# Comments for Planning Application 24/00171/OUT

Application Number: 24/00171/OUT

Address: 24 High Street Cullompton Devon EX15 1AA

Proposal: Outline for the erection of a dwelling with some matters reserved and additional parking for No 24 High Street

Proposed Site Plan
scale 1:200

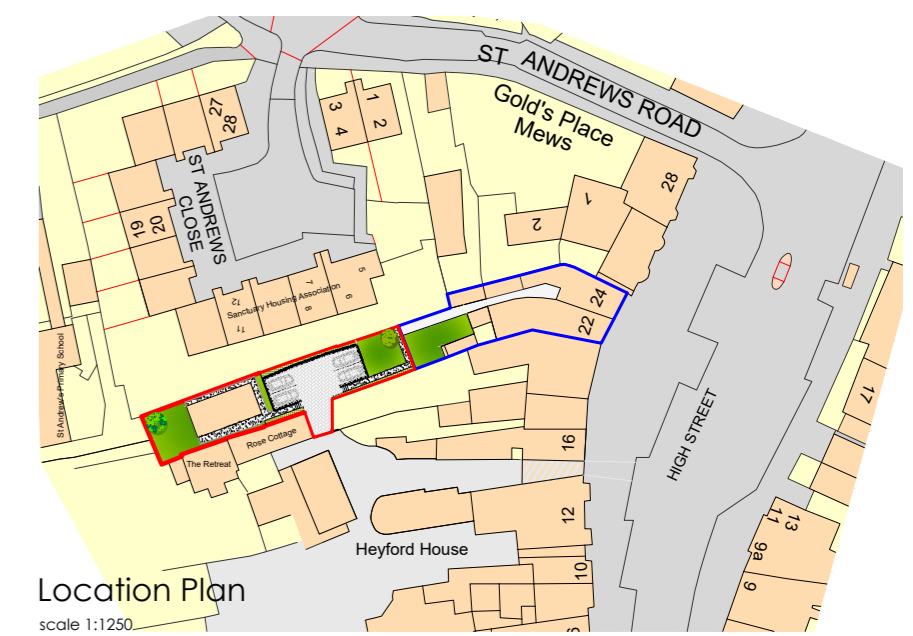
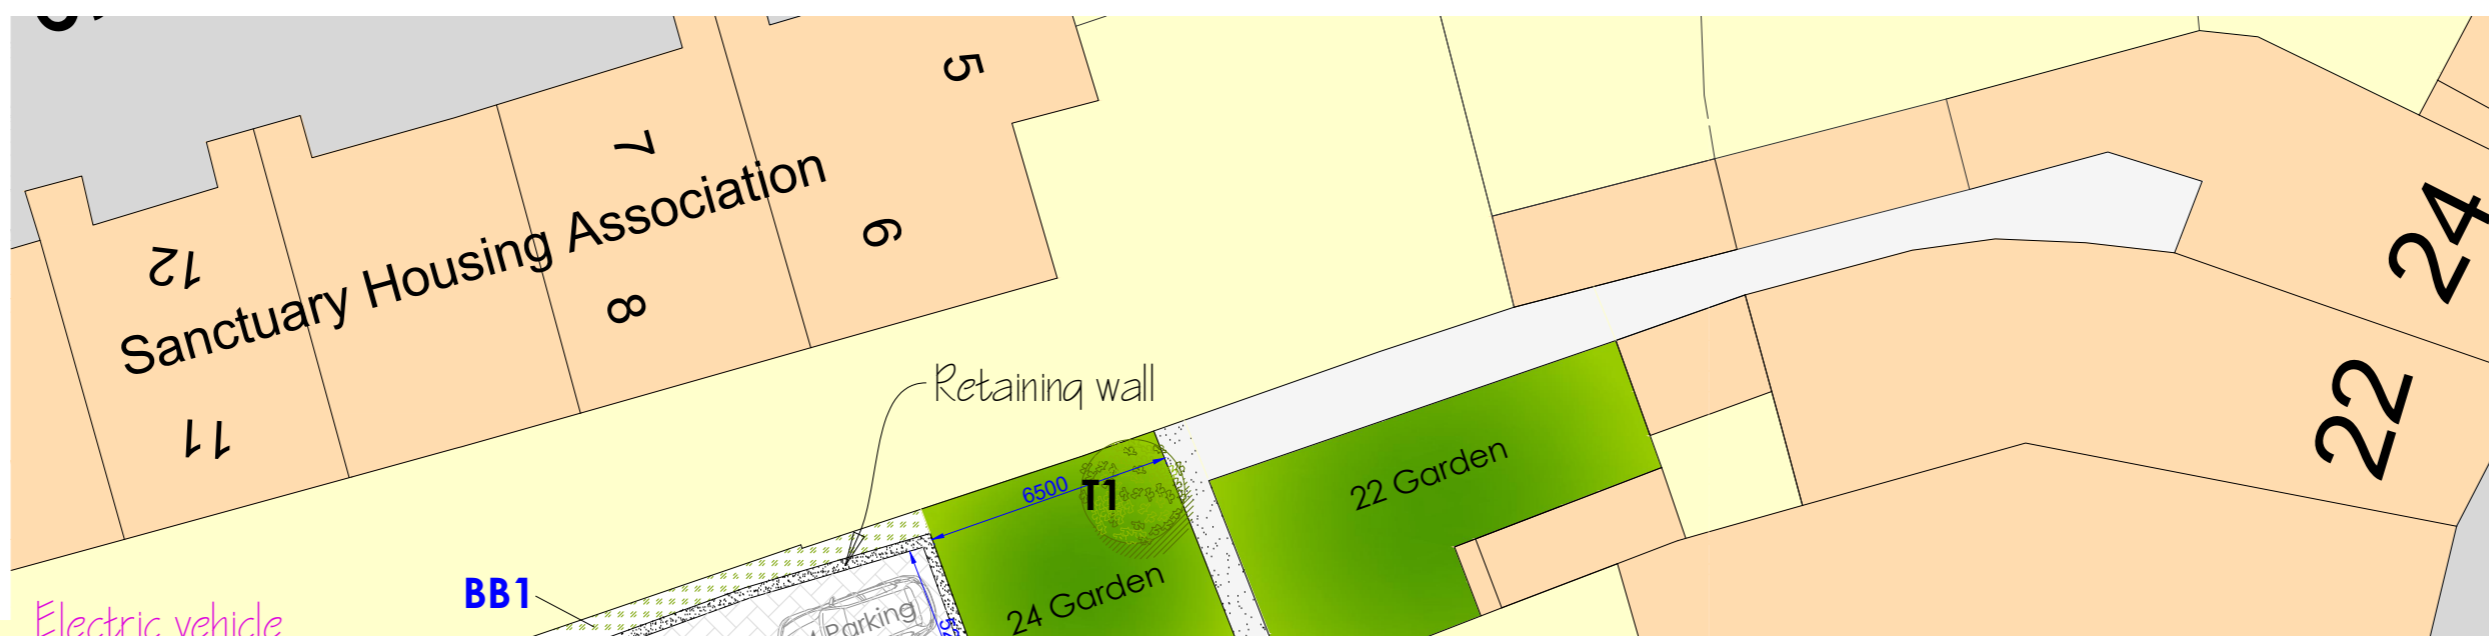
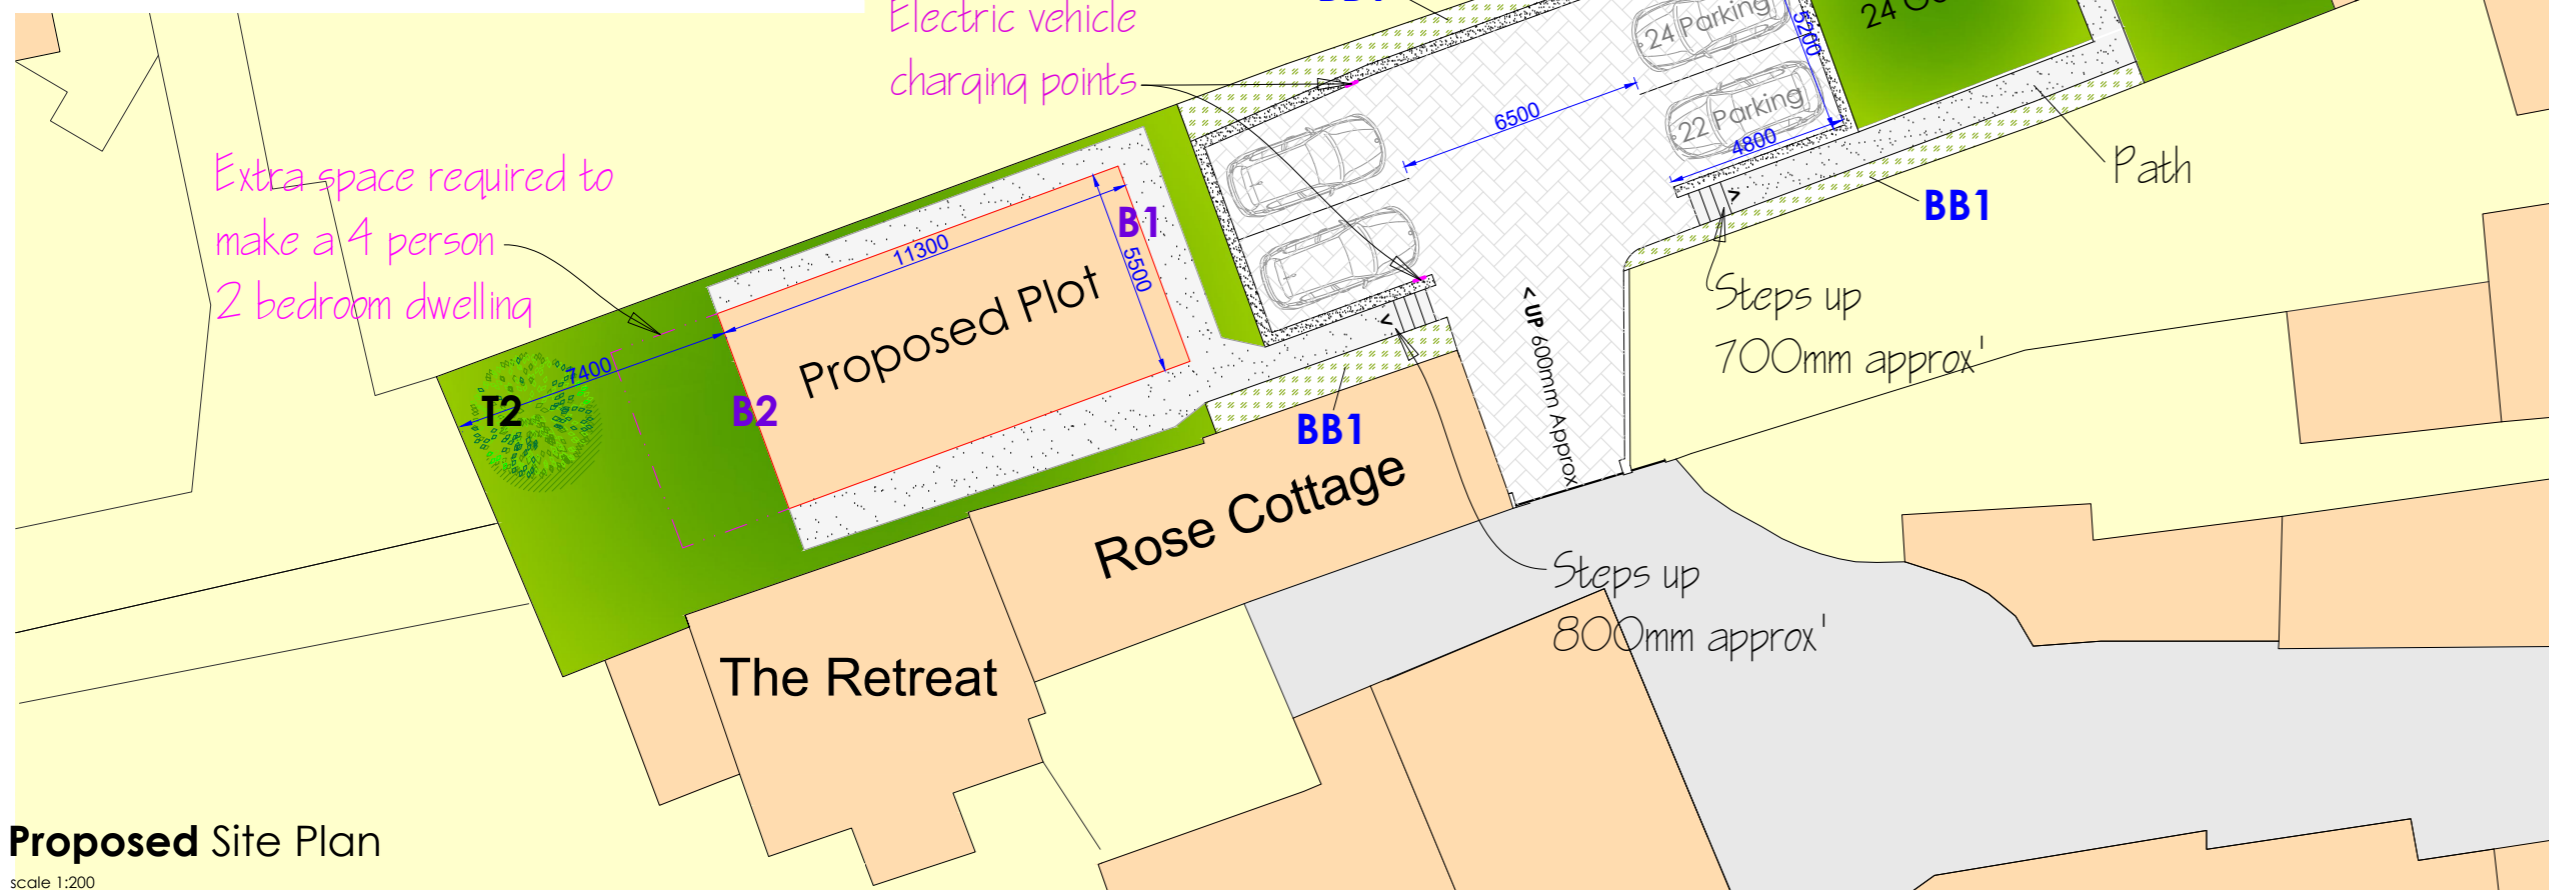
Comment: We are the tenants of Rose Cottage. The proposed development would entail knocking down the garage that is attached to our property and using that as vehicular access. The area in front of the garage is shared by all of us in the vicinity and is the only pedestrian access to our property. The plan shows four parking spaces, if they were all in use, there would be no way to turn around, and all vehicles would be reversing out through a very restricted access and over our only pathway. It would also mean an increase of vehicle movements over the lane, which is already in very poor condition and ill equipped for vehicle access. Also the proposed build looks very close to the back of our house and that would require underpinning of our back wall prior to any work taking place. We are strongly opposed to this application
